Our ref: HA/2021/123181/02-L01
Your ref: BR/124/21/OUT
Date: 25 June 2021

FURTHER INFORMATION - OUTLINE APPLICATION WITH ALL MATTERS RESERVED EXCEPT FOR ACCESS FOR DEMOLITION OF EXISTING BUNGALOW TO FORM NEW ACCESS AND RESIDENTIAL DEVELOPMENT OF 6 NO. CHALET HOUSES. THIS APPLICATION AFFECTS THE SETTING OF THE UPPER BOGNOR ROAD & MEAD LANE CONSERVATION AREA.

TO REAR OF 94 - 100 HOOK LANE BOGNOR REGIS PO22 8AT

Environment Agency Position

Modelled Flood Outlines (Tidal) Map. Centred PO22 8AT. Created 10/7/18.

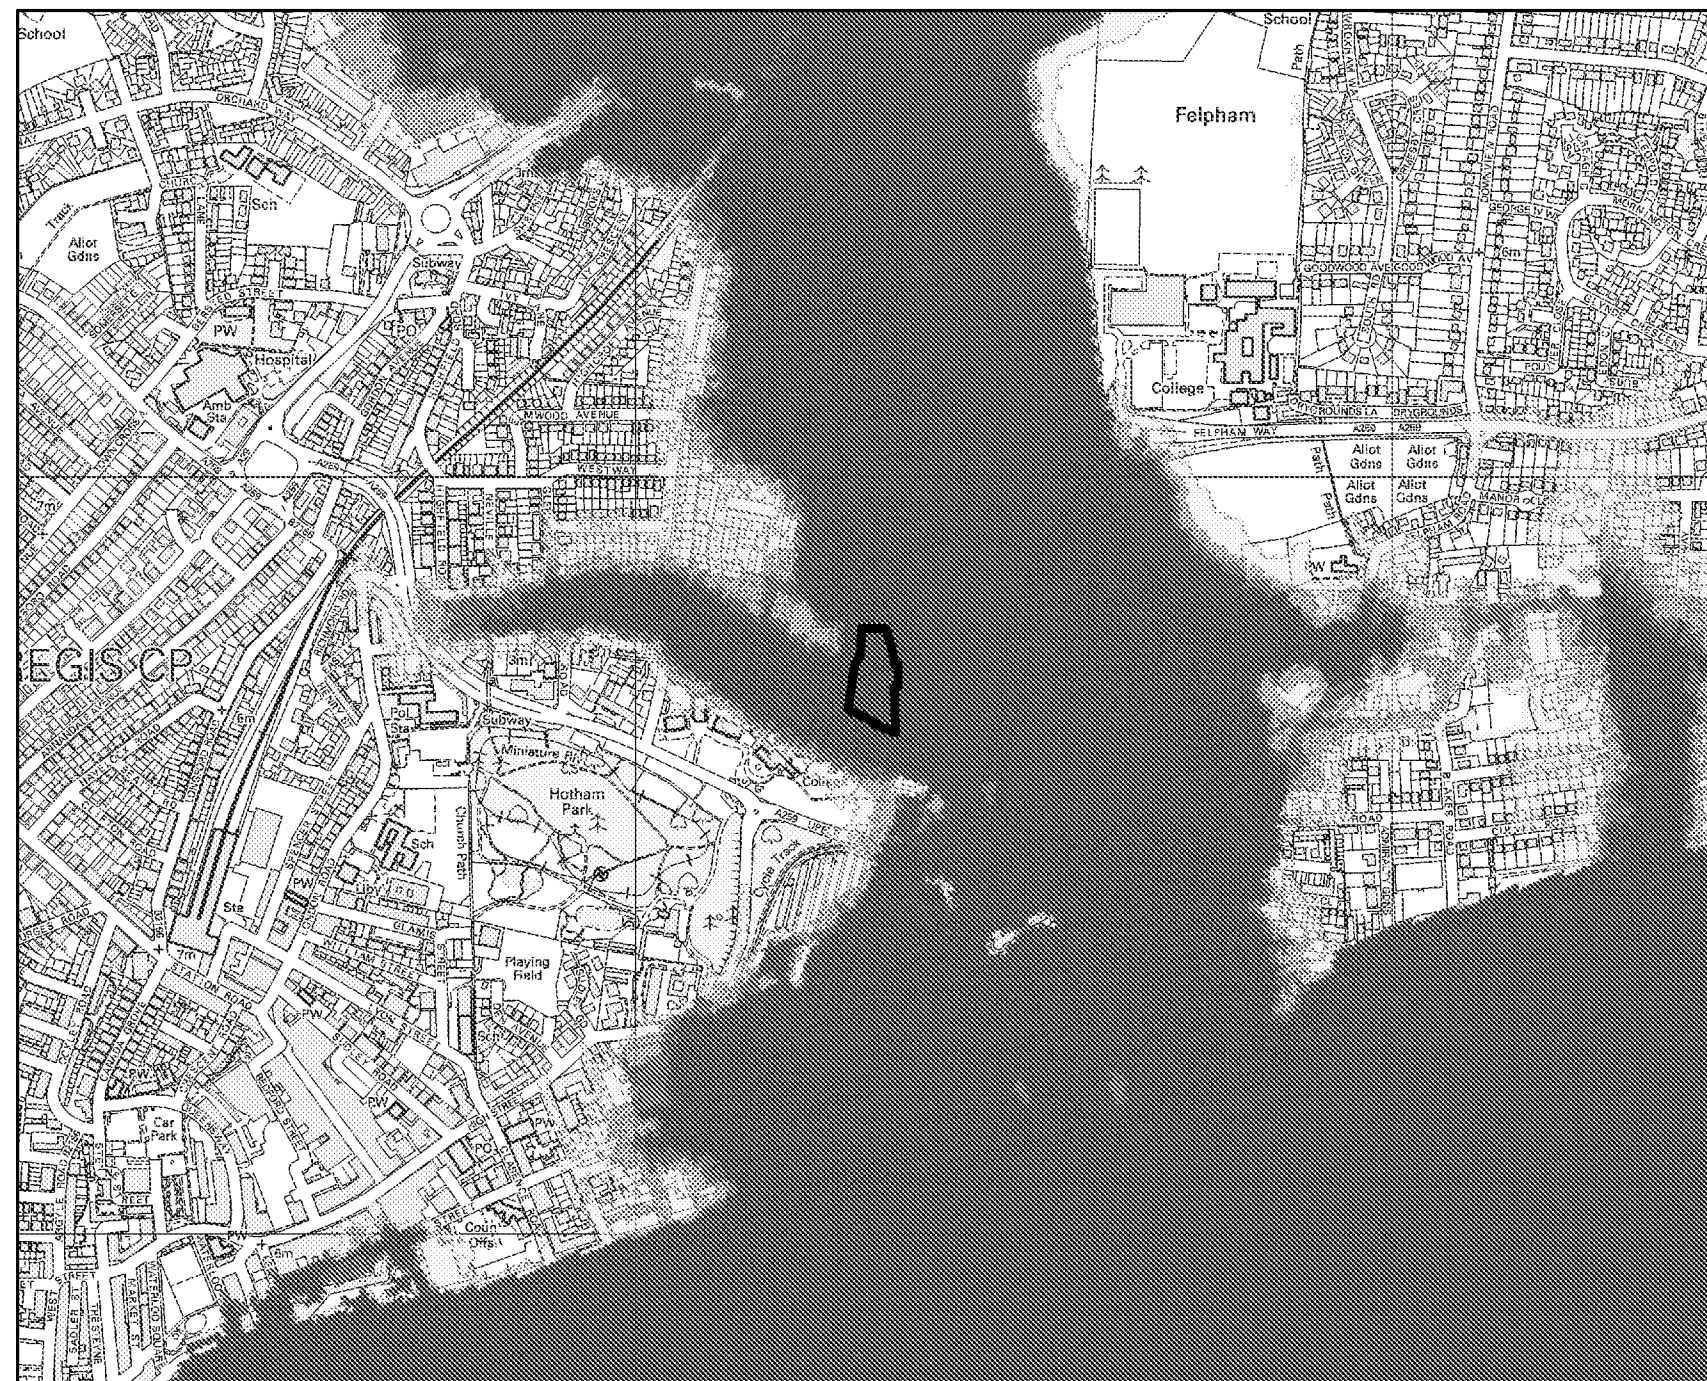
The submitted flood risk assessment (FRA) (July 2018, WSP) fails to address the tidal flood risk and demonstrate that the development will be safe for its lifetime considering all sources of flooding. Climate change allowances were updated on 17 December 2019, please visit <https://www.gov.uk/guidance/flood-risk-assessments-climate-change-allowances> for the latest guidance.

FLOOD COMPENSATION AREA

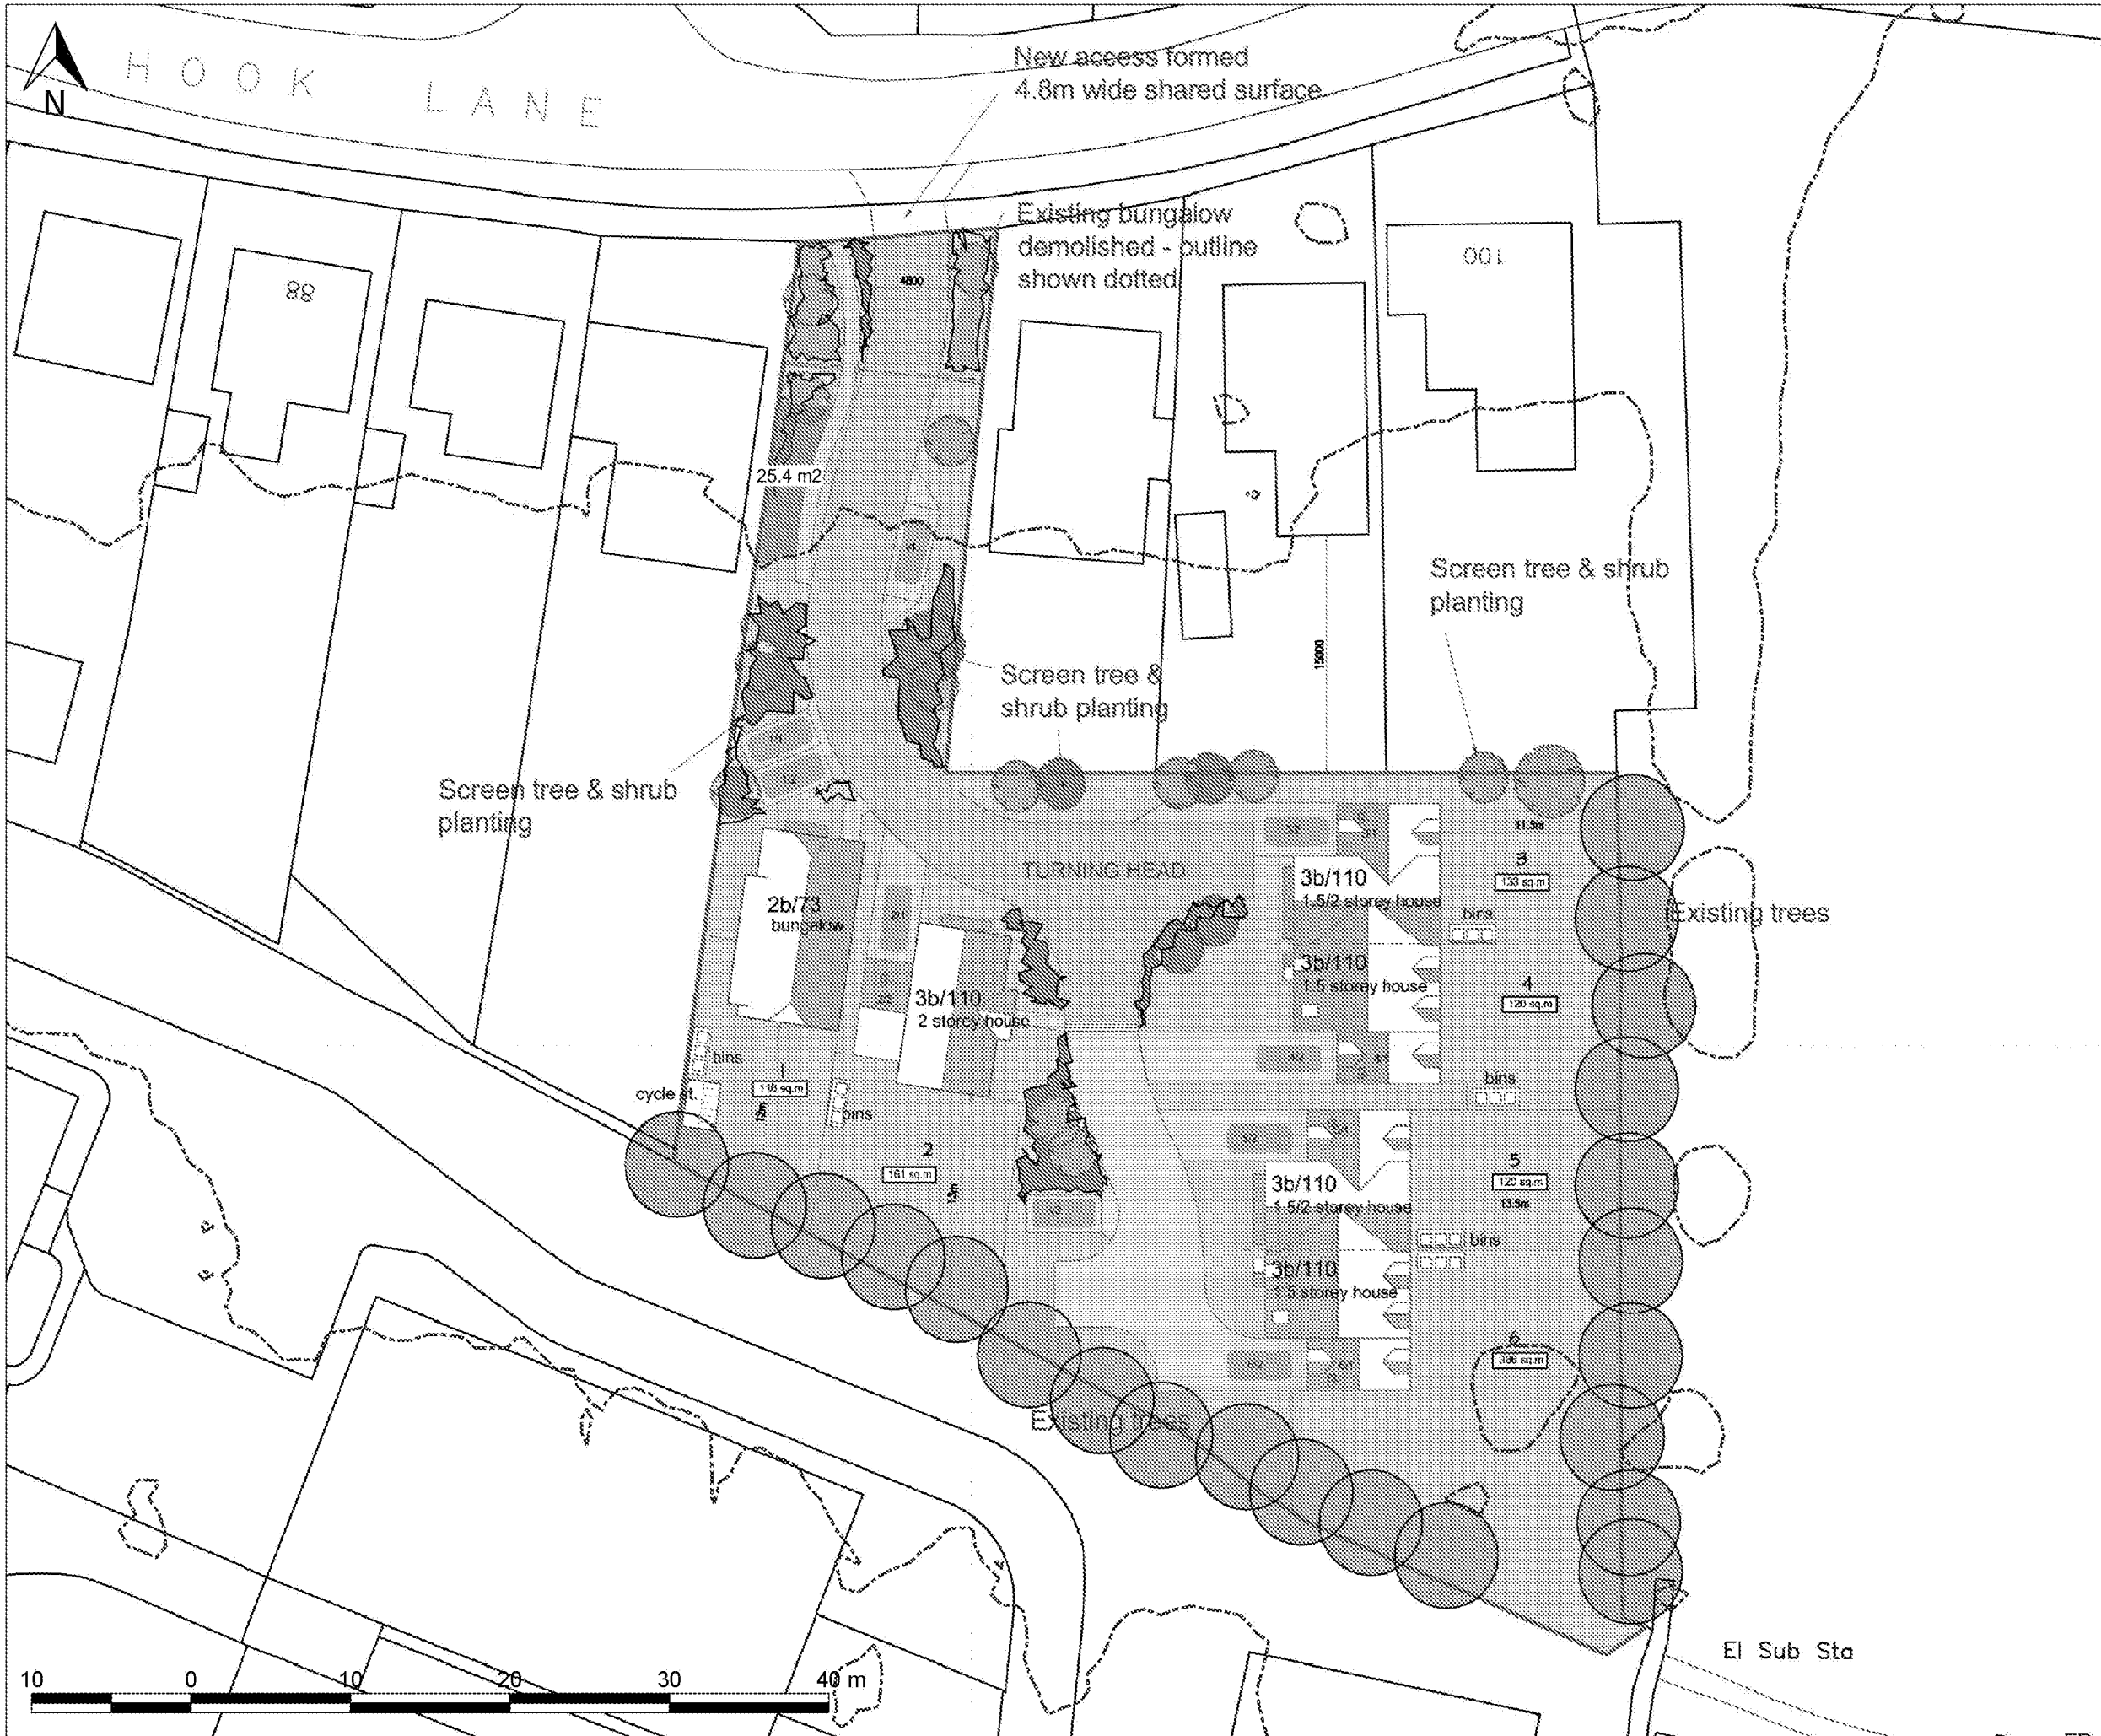
We also still have reservations on the use of voids and will need further reassurance that the proposed flood plain compensation will be effective.
